April 4, 2023

**Re: Champion Xpress Car Wash – 221 Unser Blvd SW
Erosion and Sediment Control Plan
Engineer's Stamp Date - Missing (K10E064)**

Based upon the information provided in your submittal received 2/22/2023, the above referenced ESC Plan cannot be approved until the following comments are addressed:

Design: RJM	Proj: 22.146
Draw: RMM	Dwg: 22-146.dwg
Check: RJM	Tab: C6.0-SWP3
Scale: 1" = 30'	
Date: 01.11.2023	
Sheet: EROSION CONTROL PLAN	
Sheet No.: C-6.0

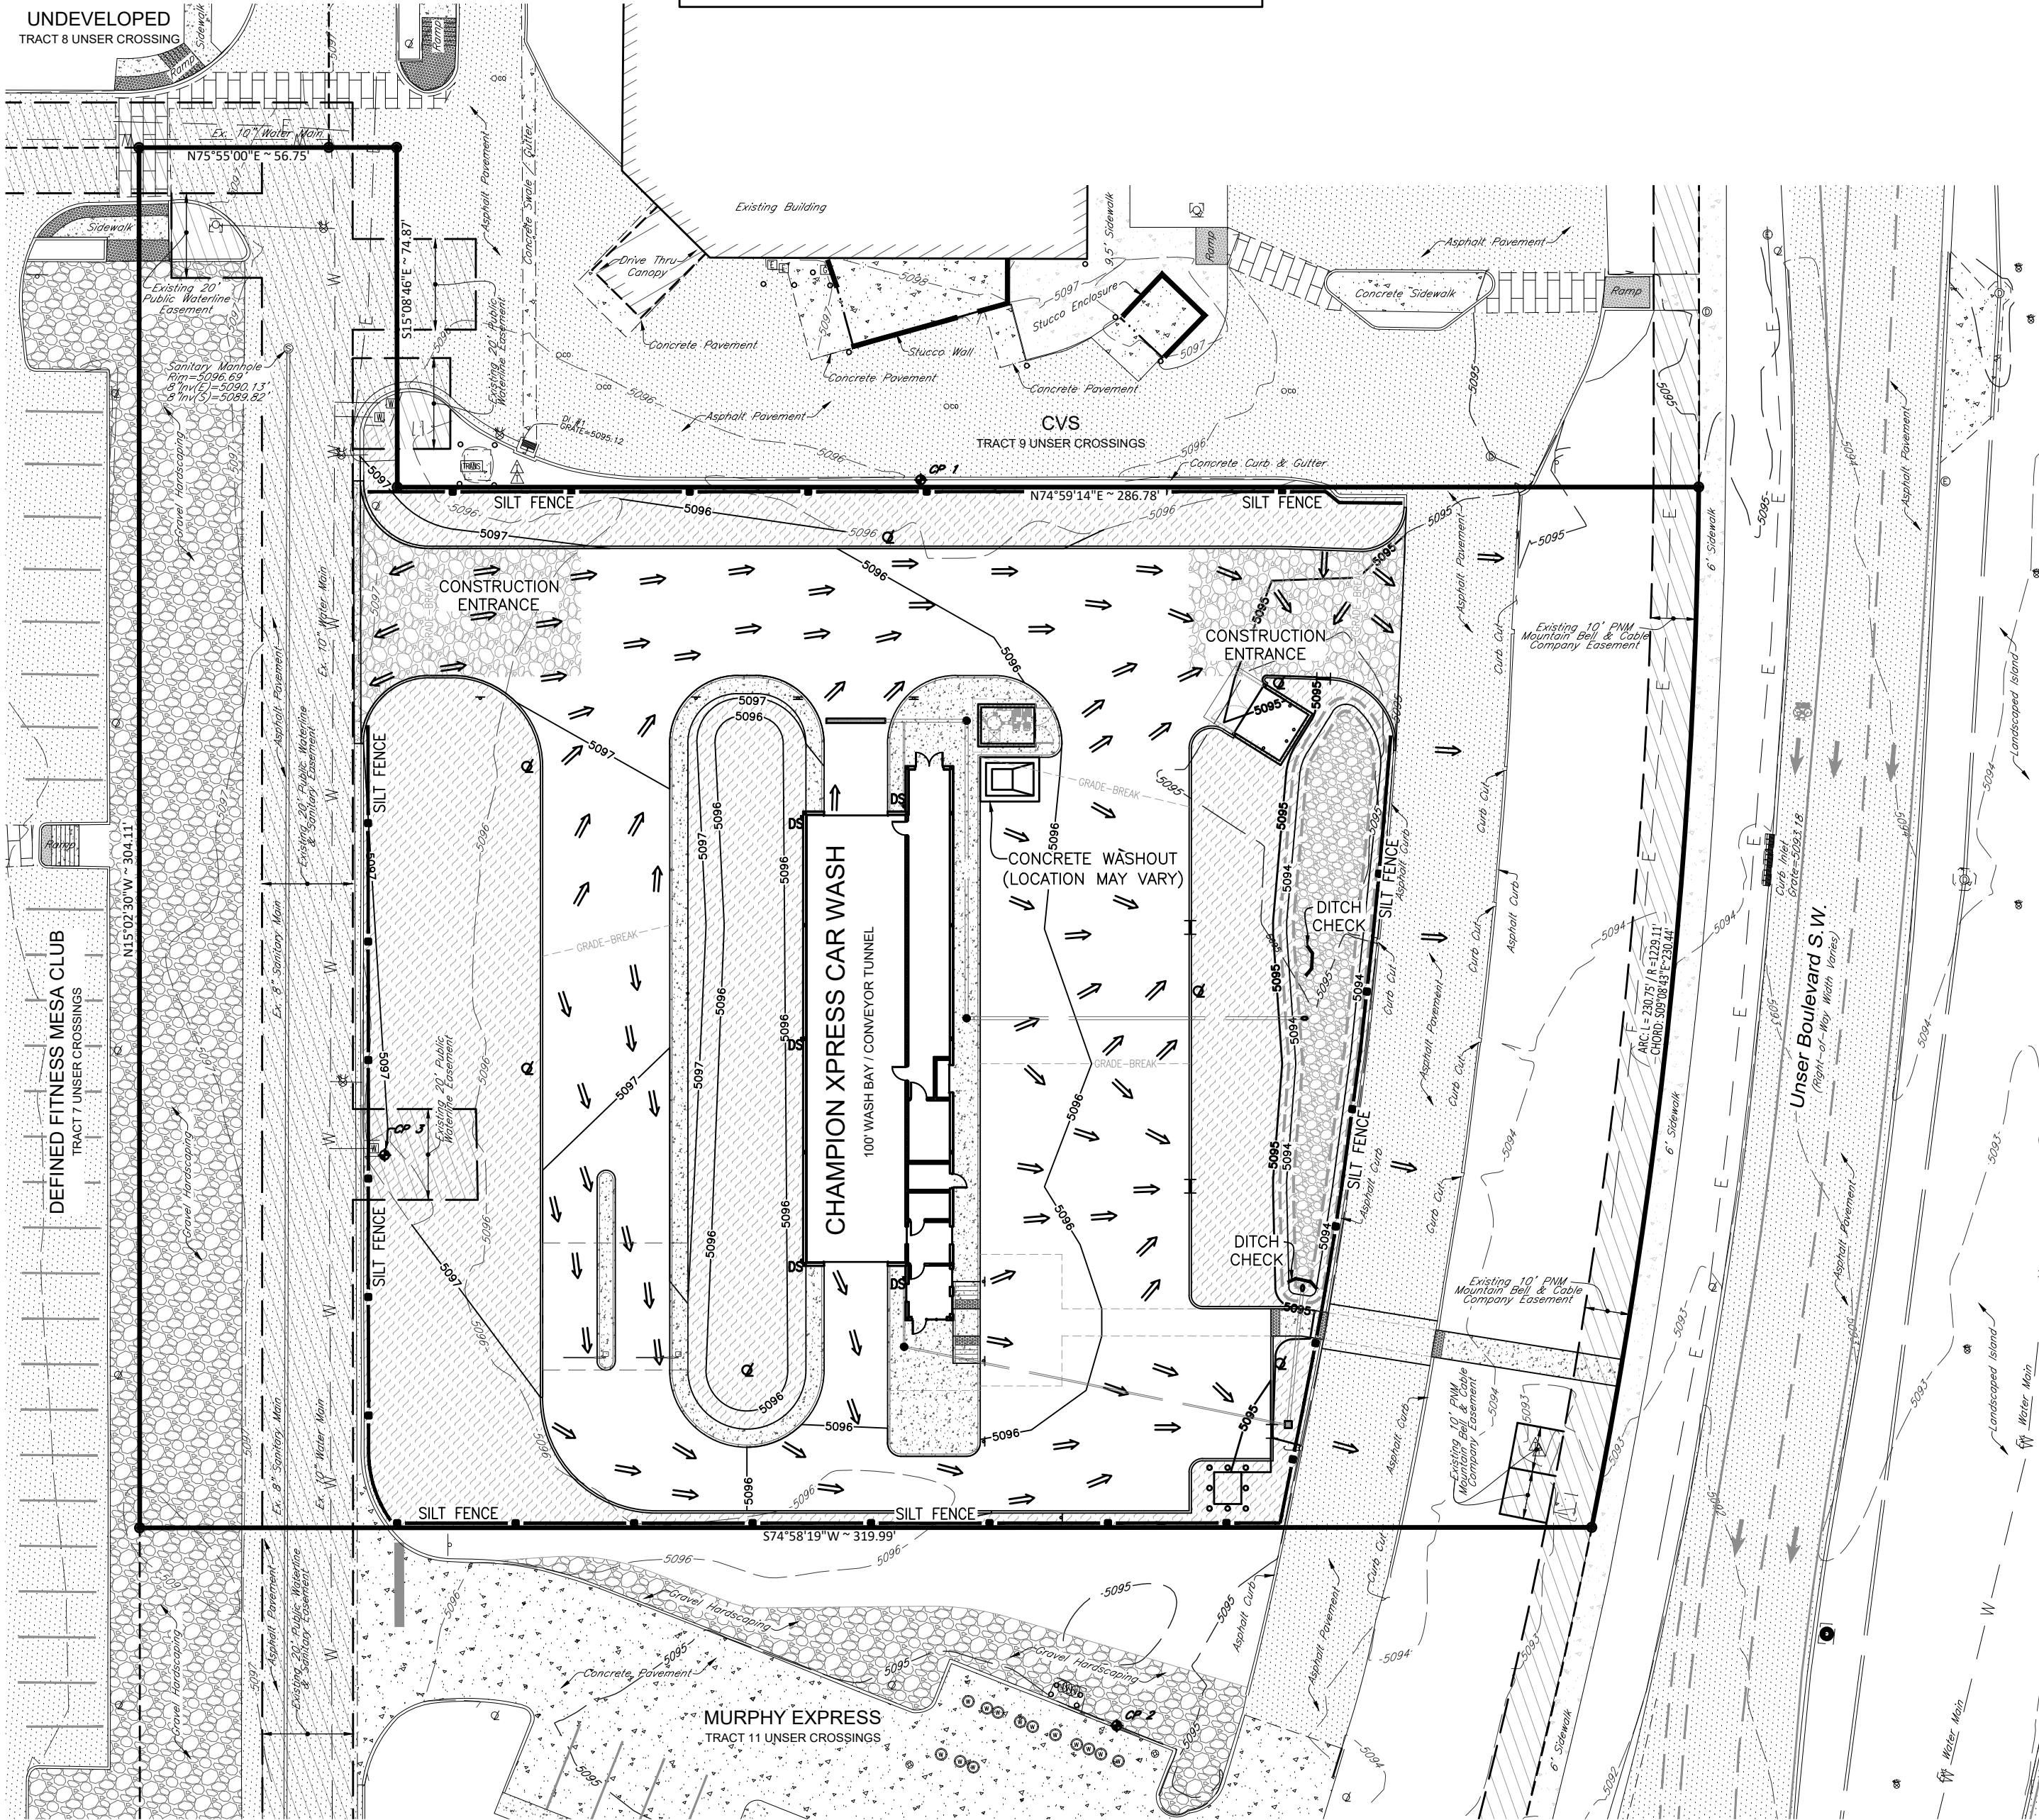
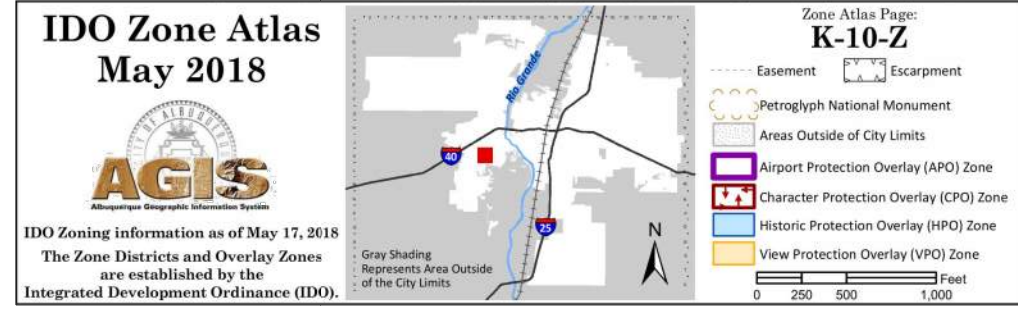
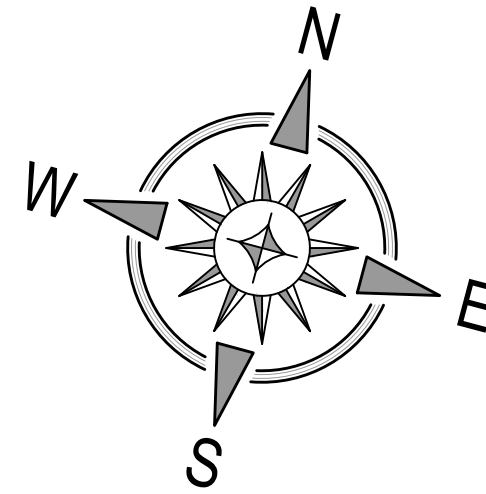
1. The owner information shown on the Information Sheet (Via Real Estate, LLC.) and the NPDES documentation (7B Building and Development), form does not agree with the available Bernalillo County records (Armstrong Central Unser Blvd., LLC). Property rights may have changed hands recently, if so, please provide documentation in the form of a recorded deed or lease. The accurate name and contact information for the entity in control of the property rights is required and should also be shown on the plan.

3. Update the engineer's stamp date each time the plan is changed. The stamp, signature, and date must be on the two sheets (C-6.1 and C-6.2) of the ESC plan and that stamped sheet must be in the Building Permit plans after it is approved by The Stormwater Section of the Planning Department.

Design: REB	Proj: 22.146
Draw: REB	Dwg:
Check: REB	Tab: L-1.0
Scale: 1"=20'	
Date: 01.11.2023	
Sheet: LANDSCAPE PLAN	
Sheet No.: L-1.0

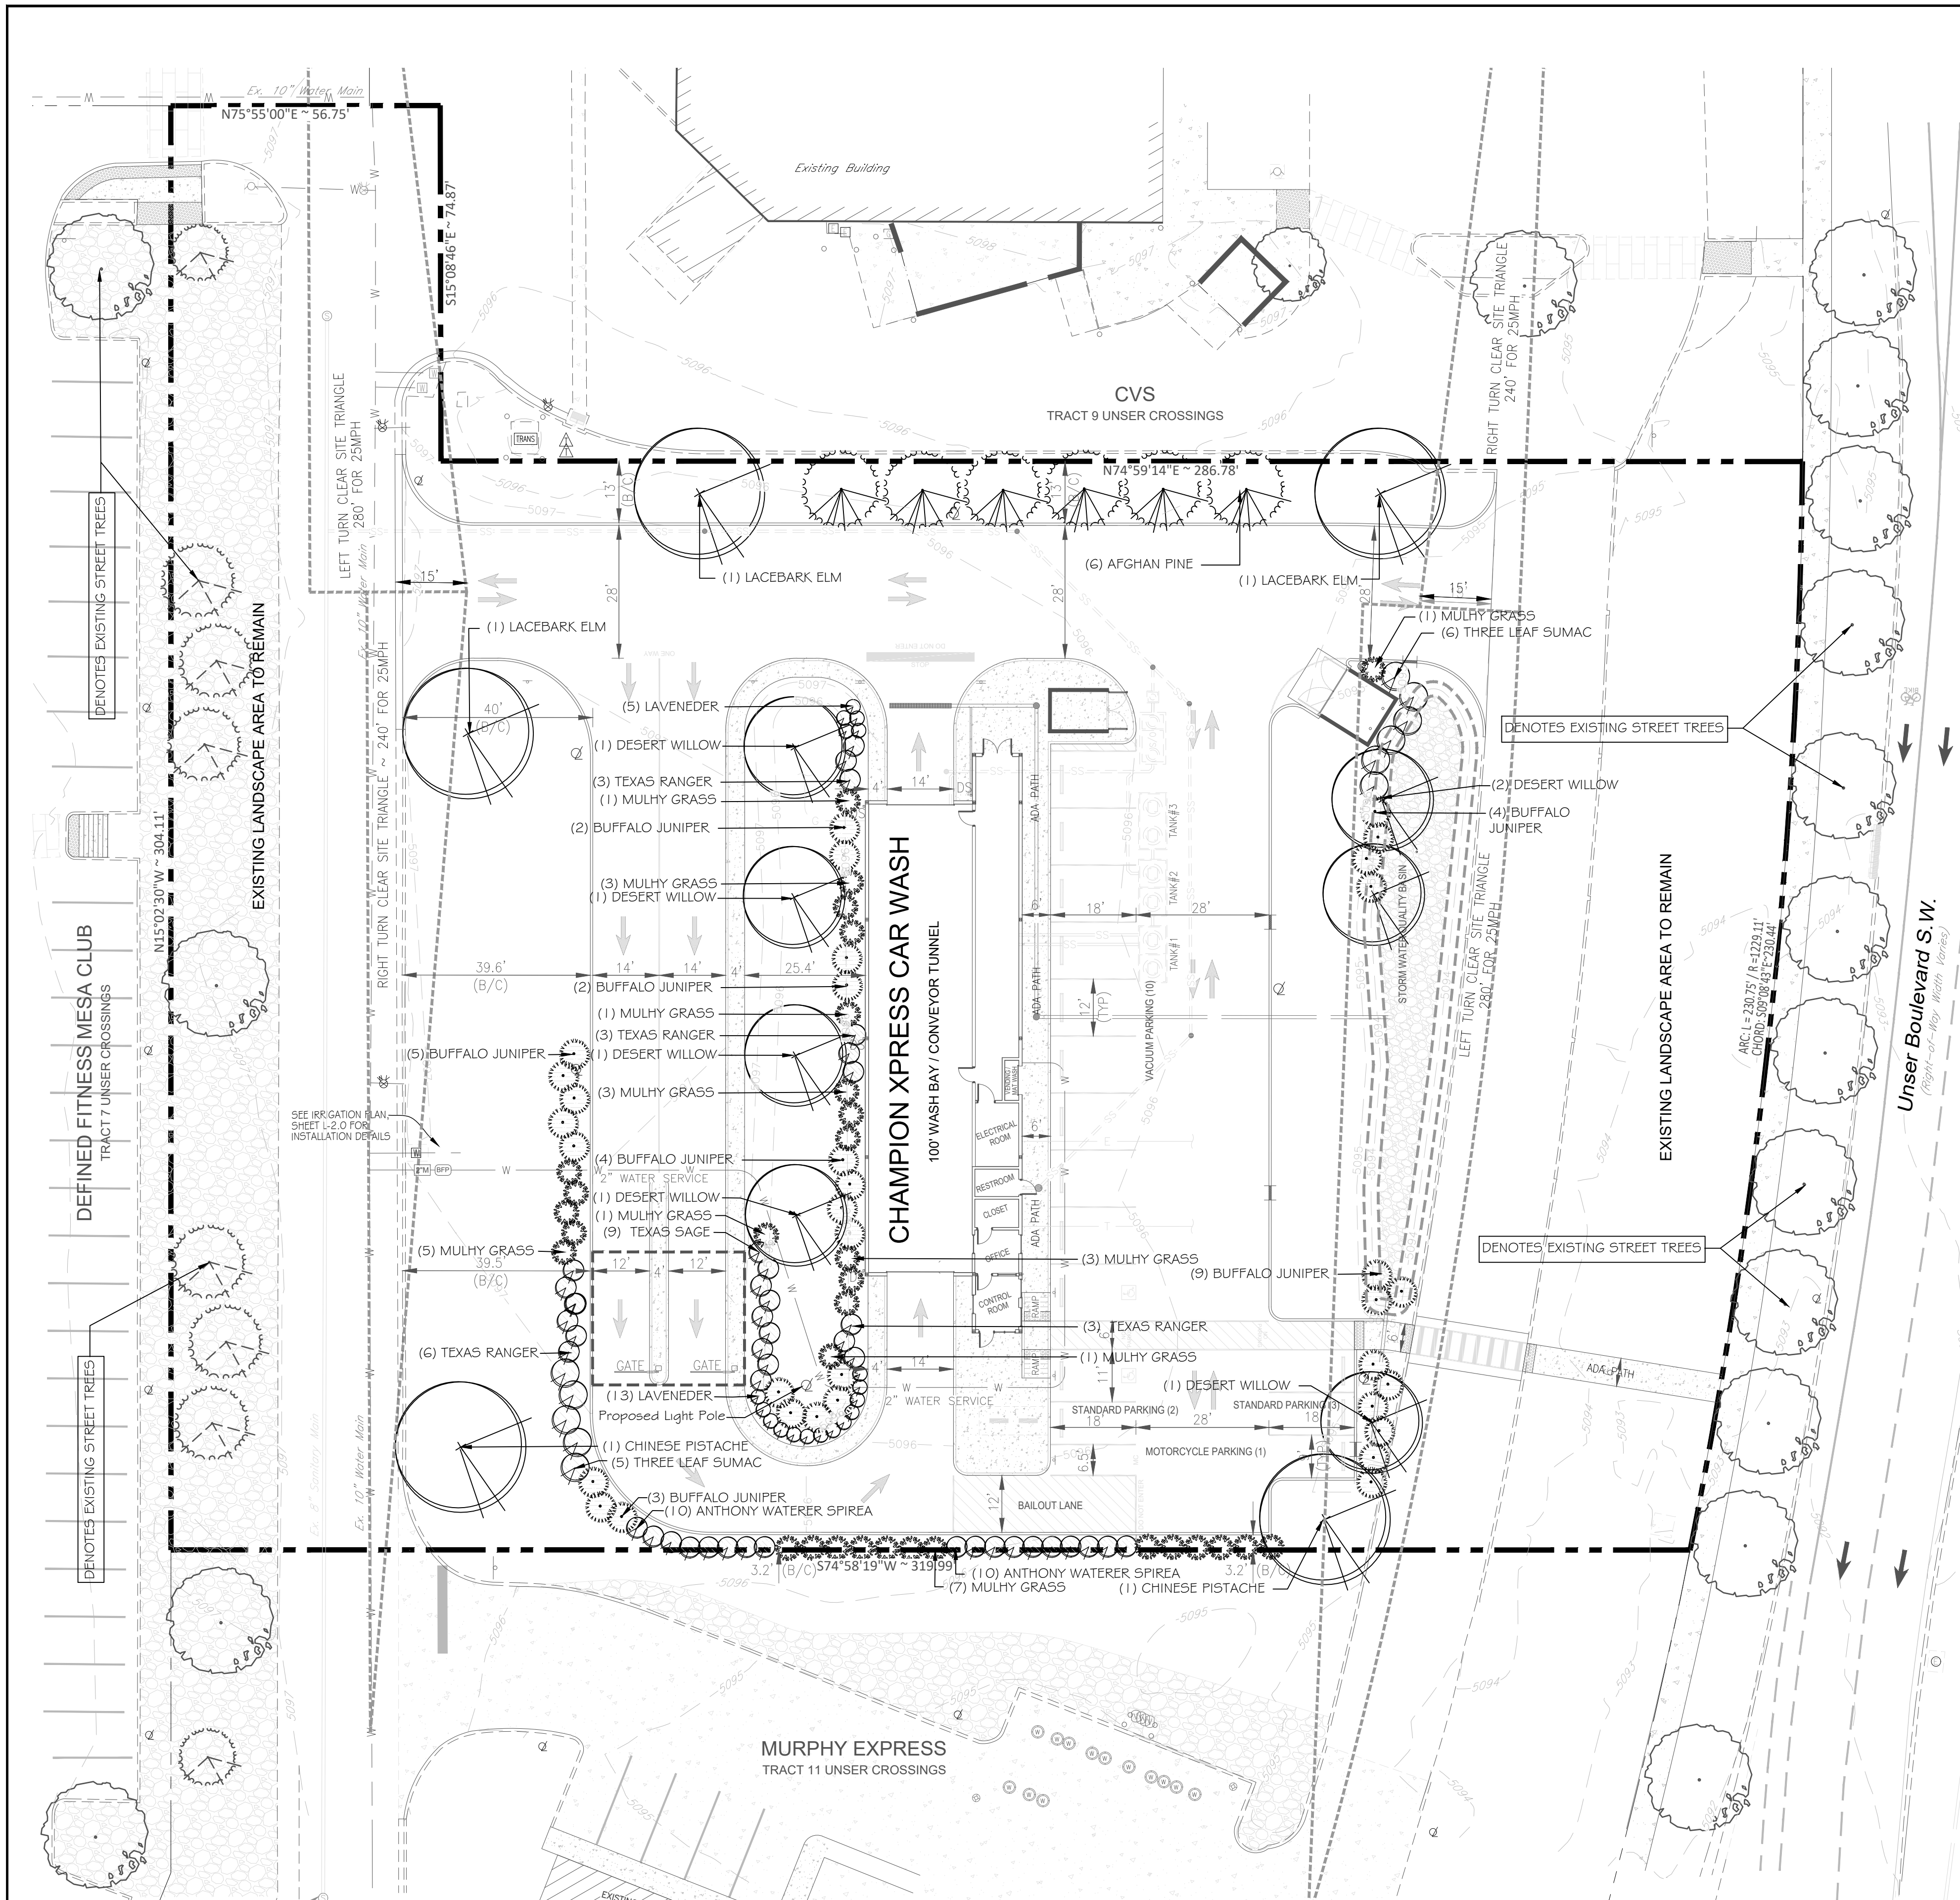
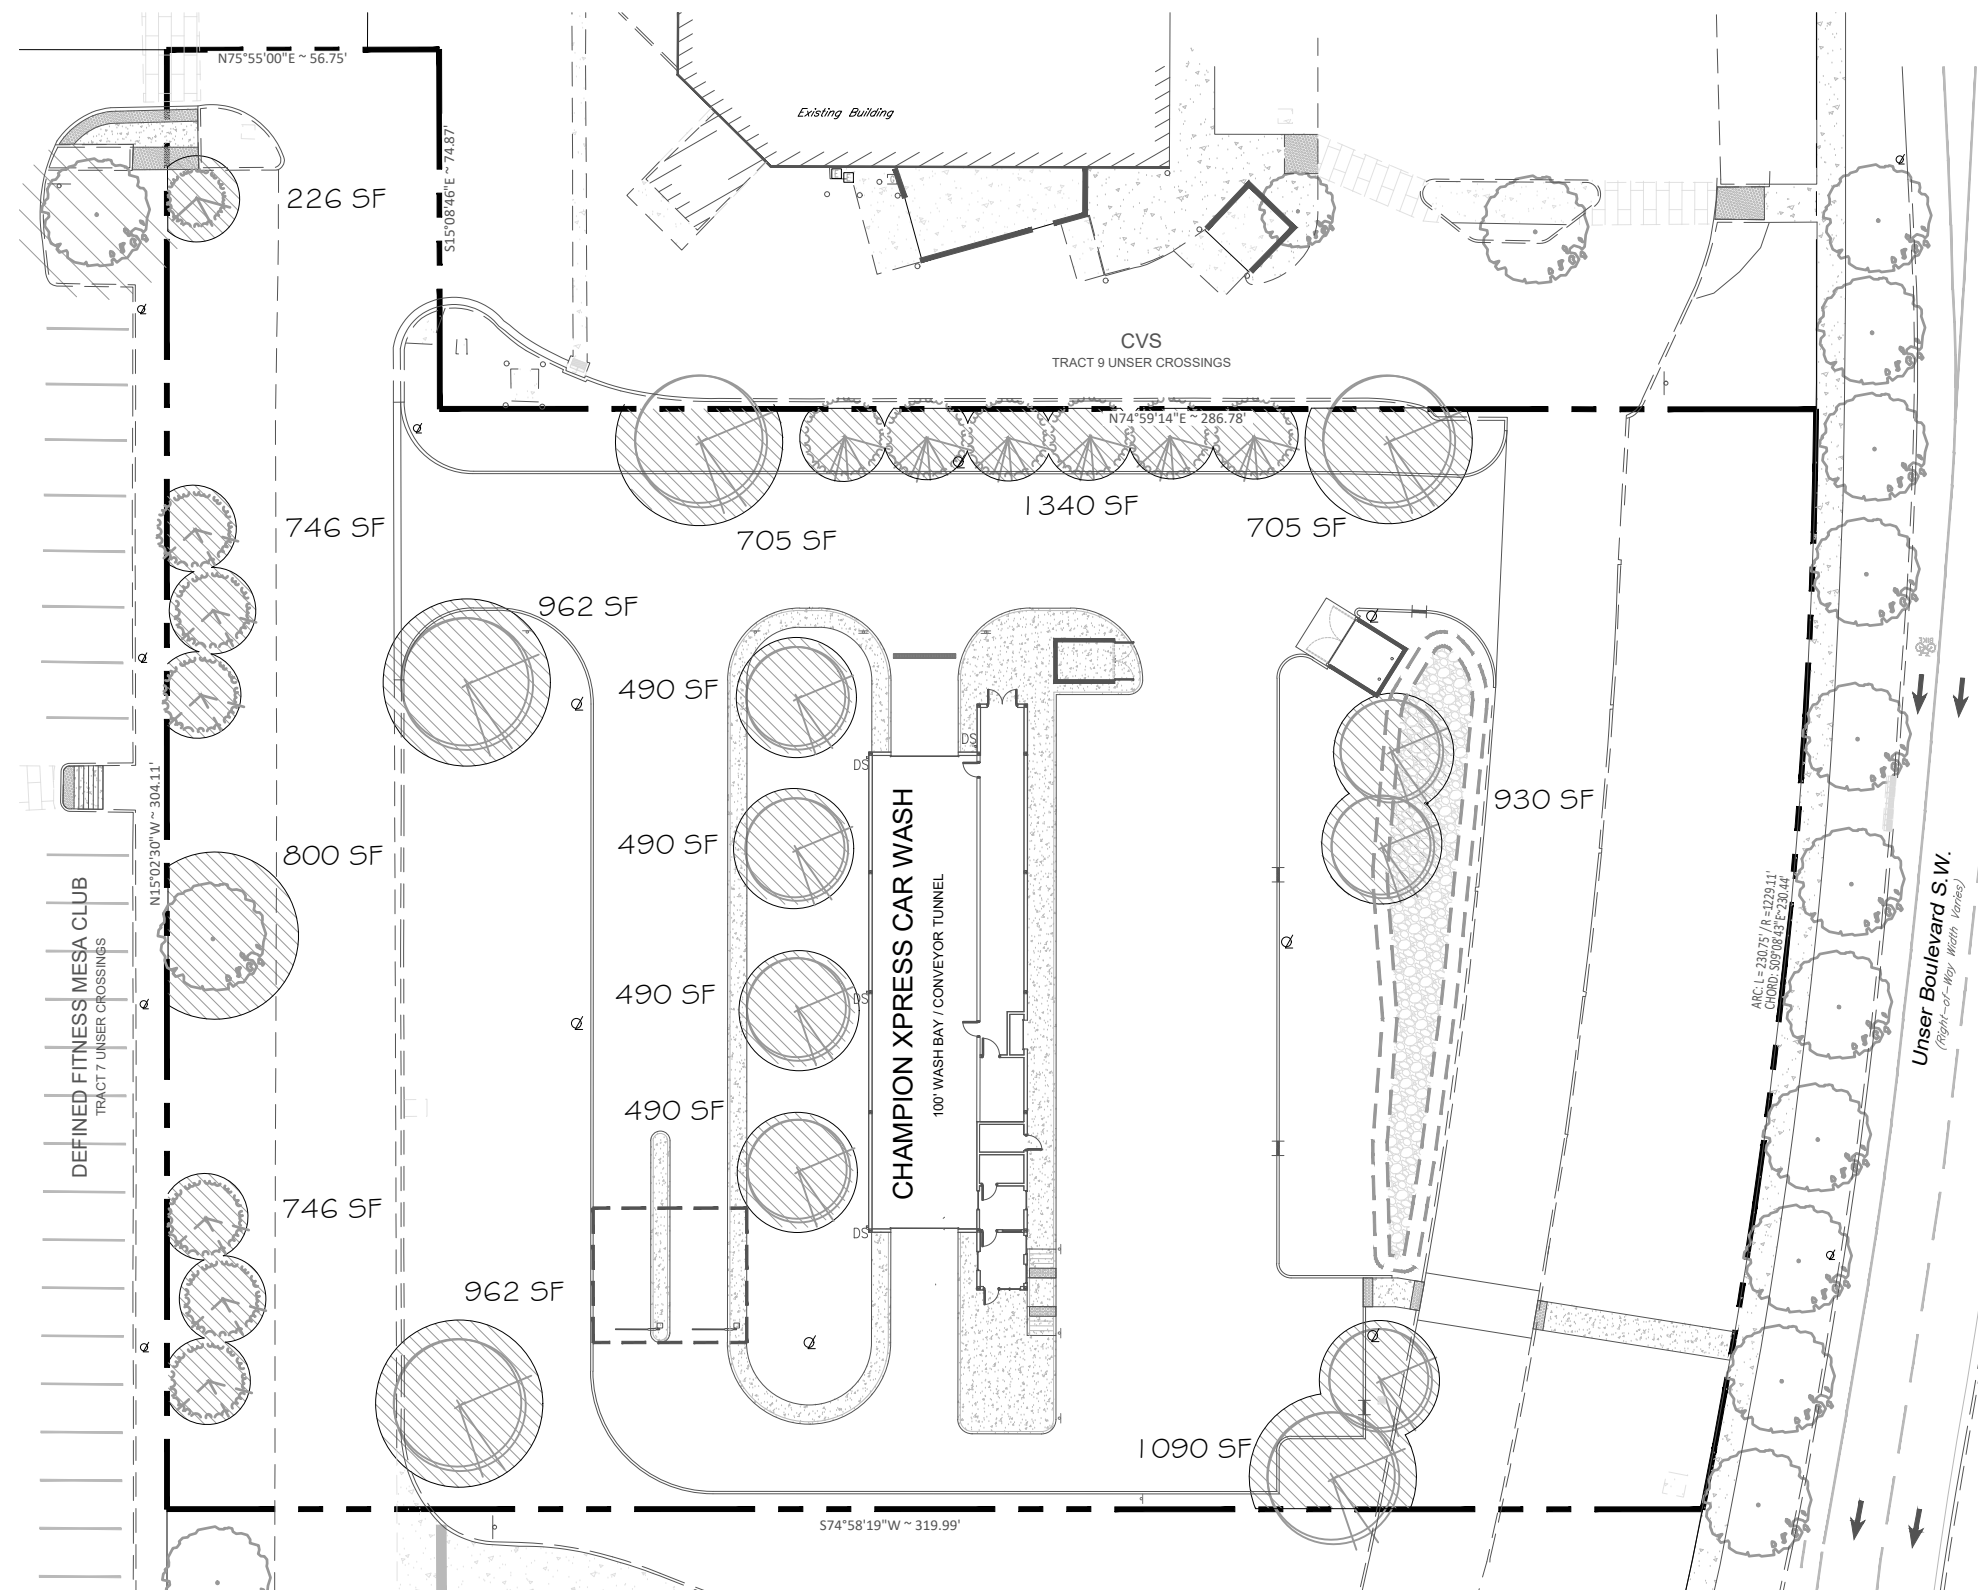
2. Stabilization measures (CGP 7.2.6.b.vi), including **Specific** vegetative and non-vegetative practices and deadlines, must be identified. The landscape plan can be used to satisfy this requirement and should be included (on sheets separate from the ESC Plan) in the SWPPP and the ESC Plan submittal
